Our ref: OUT22/6304

Subject: **Valley of the Winds Wind Farm (SSD-10461) - Environmental Impact Statement (EIS)**

# Detailed advice to DPE Planning & Assessment regarding the Valley of the Winds Wind Farm (SSD-10461) - EIS

Figure 2.1: Project area and location

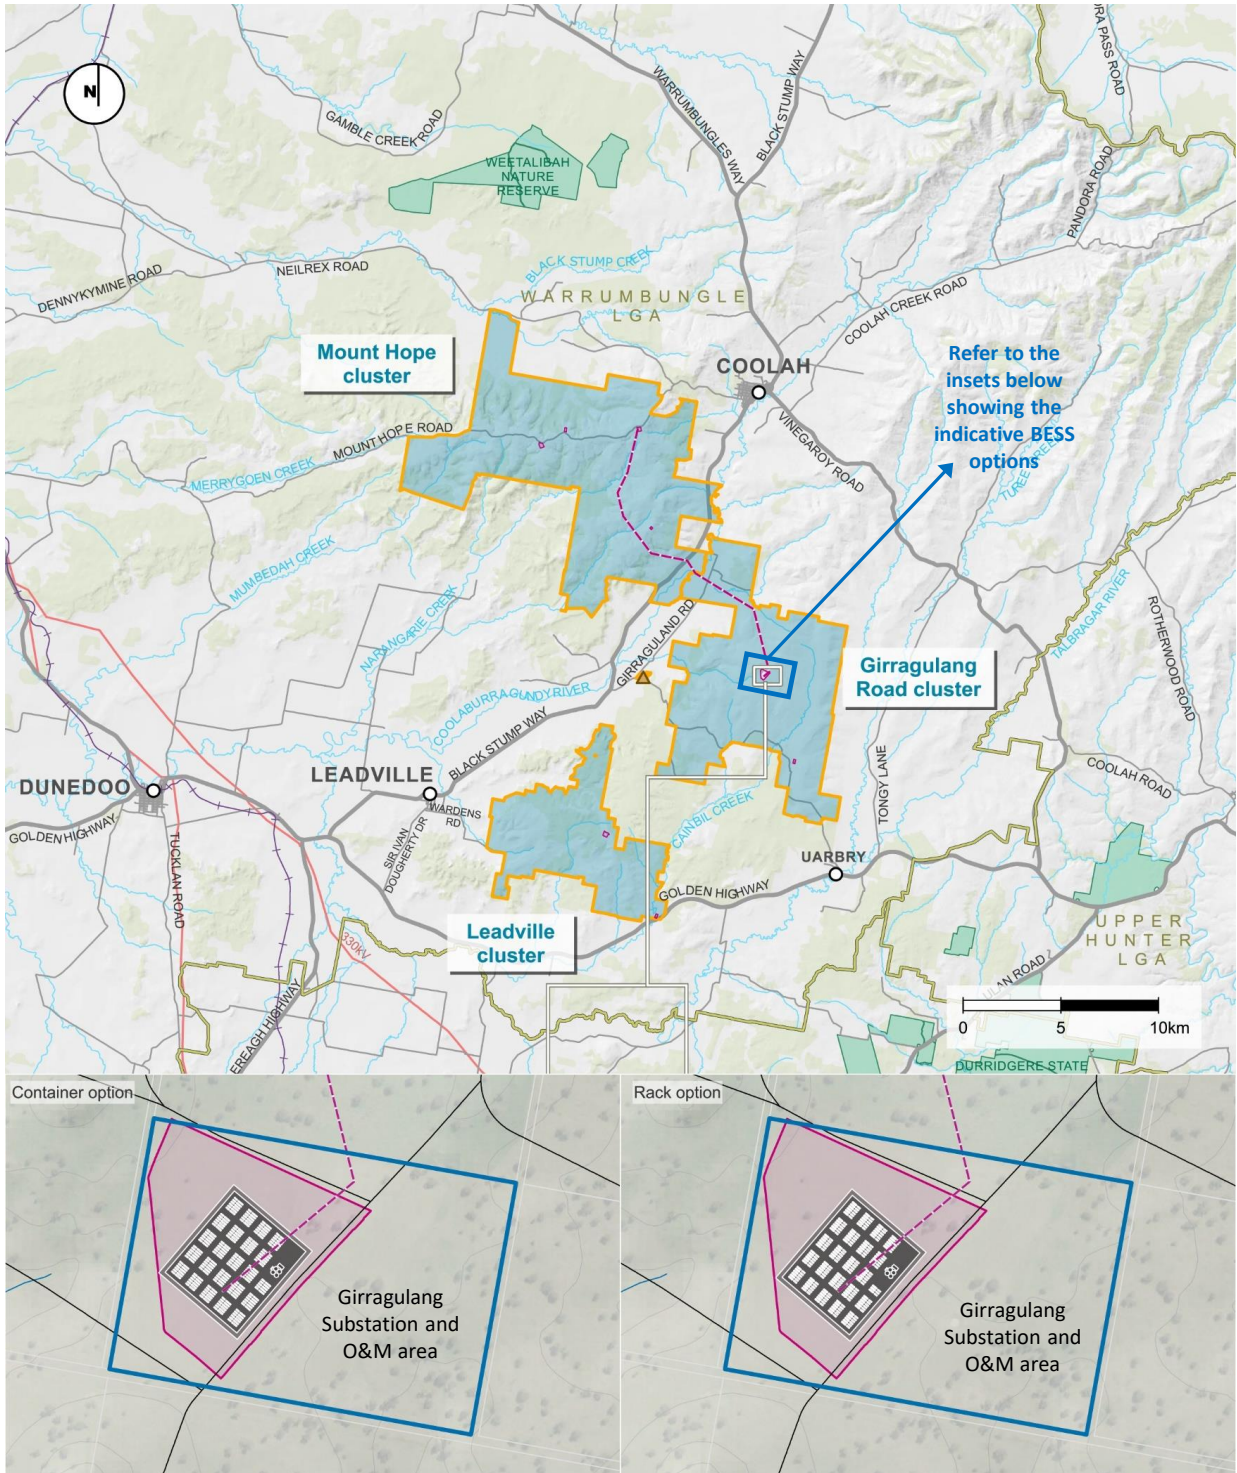
- Clarification should be provided of the proposed infrastructure layout to meet the buffer requirements from watercourses as defined in the Guidelines for Controlled Activities on Waterfront Land (NRAR 2018)

Clarification is requested for the proposed infrastructure layout to meet the buffer requirements from watercourses as defined in the Guidelines for Controlled Activities on Waterfront Land (NRAR 2018). It is currently unclear if the setbacks have been provided particularly for the quarry locations and permanent operations and maintenance compounds.
